Developer Services
Southern Water
Sparrowgrove House
Sparrowgrove
Otterbourne
Hampshire
SO21 2SW

Your Ref
WA/59/18/HH
Our Ref
PLAN-023873
Date
16/08/2018

Proposal: Single storey rear & side extensions, new front porch, new door to ground floor east elevation & loft conversion.
Site: 27 Pound Road, Walberton, BN18 0PU.
WA/59/18/HH

PROPOSED BLOCK/ROOF PLAN 1:200

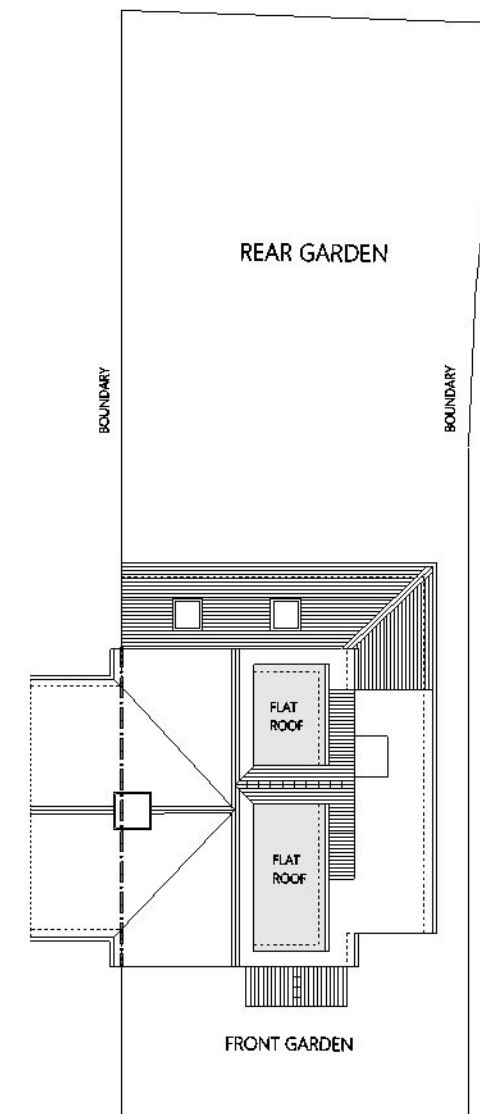
It appears that the developer is intending to build over to a public foul sewer which is crossing the site. Building over a "public sewer" is not normally permitted by Southern Water.

However, under certain circumstances building over a minor sewer may be allowed. The conditions associated with the build over to a sewer are contained in Southern Water guidance notes which are available at: www.southernwater.co.uk. A formal application to build over to the sewer will required to be submitted by the applicant.

In order to protect drainage apparatus, Southern Water requests that if consent is granted, a condition is attached to the planning permission For example: “The developer must agree with Southern Water, prior to commencement of the development, the measures to be undertaken to protect the public sewer.”
